Item No. **Report of the Head of Development Management and Building Control**

Address: 42 HALFORD ROAD ICKENHAM

Development: Erection of a single storey front/side extension and rear extension
amendments to fenestrations including new side door (revised plans)

LBH Ref Nos: 21435/APP/2023/3152

Proposed Front Elevation

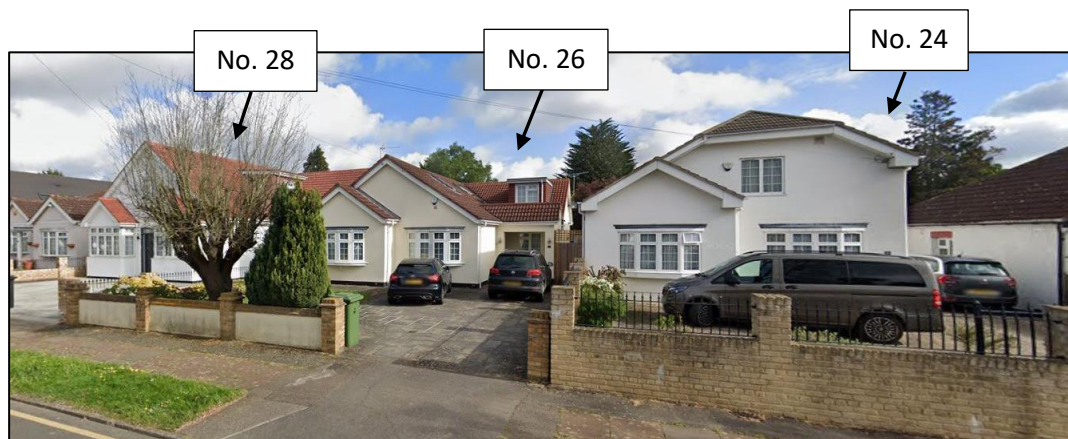
The application property features a main pitched gable roof and a pitched protruding gable to the front. The front gables are an existing design and is a design feature that is relatively synonymous in the surrounding area. Whilst a number of properties within the immediate area have been extended over time, a number have retained their original front design and this provides a good degree of symmetry within the area. The application proposes a single storey front infill extension which will align with the protruding gable feature and wraparound to the side and rear, extending well forward of the existing single storey side extension. The front/side proposal would measure a depth of approximately 4.4m, a width to the front of approximately 6.1m, and would feature a hipped crown roof measuring a maximum height of 3.5m.

The proposed front infill would result in the loss of the existing stepped building line and prominence of the front gable, and would have an adverse impact on the relationship of the existing front gables. Moreover, the crown roof design would fail to respect the architectural composition of the host dwelling and not appear as a visually subordinate and complementary addition.

Proposed Eastern Side Elevation

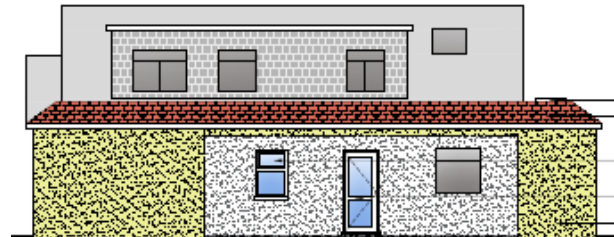
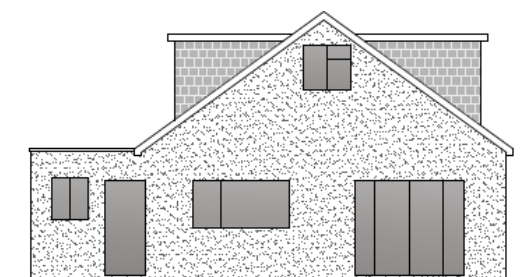
The application involves the loss of the pitched roof feature viewed from the front of the property. This feature is preferable to the total flat roof option now proposed. It would be preferable if the new window and glazed door to the side elevation were to contain obscured glass.

Proposed Rear Elevation

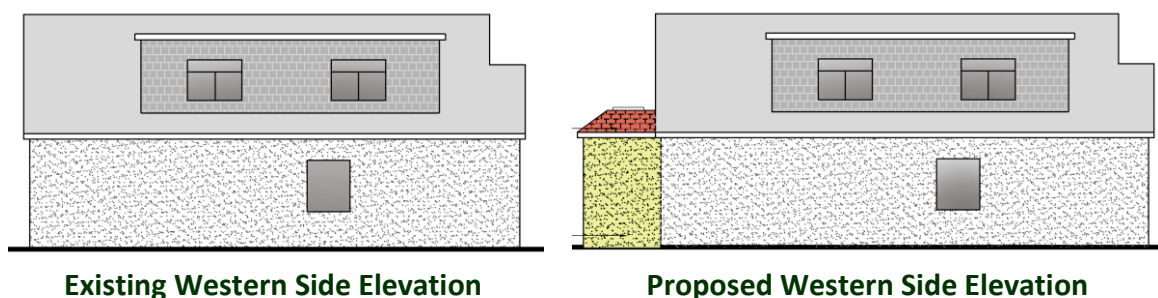
It is noted that the dwelling benefits from a two storey rear extension which is approx. 2.875m deep. The proposed single storey rear extension would add an additional 2m at ground floor. The depth of 4.875m from the original rear would exceed local policy. In addition, the proposed height would be 3.5m, also exceeding policy.
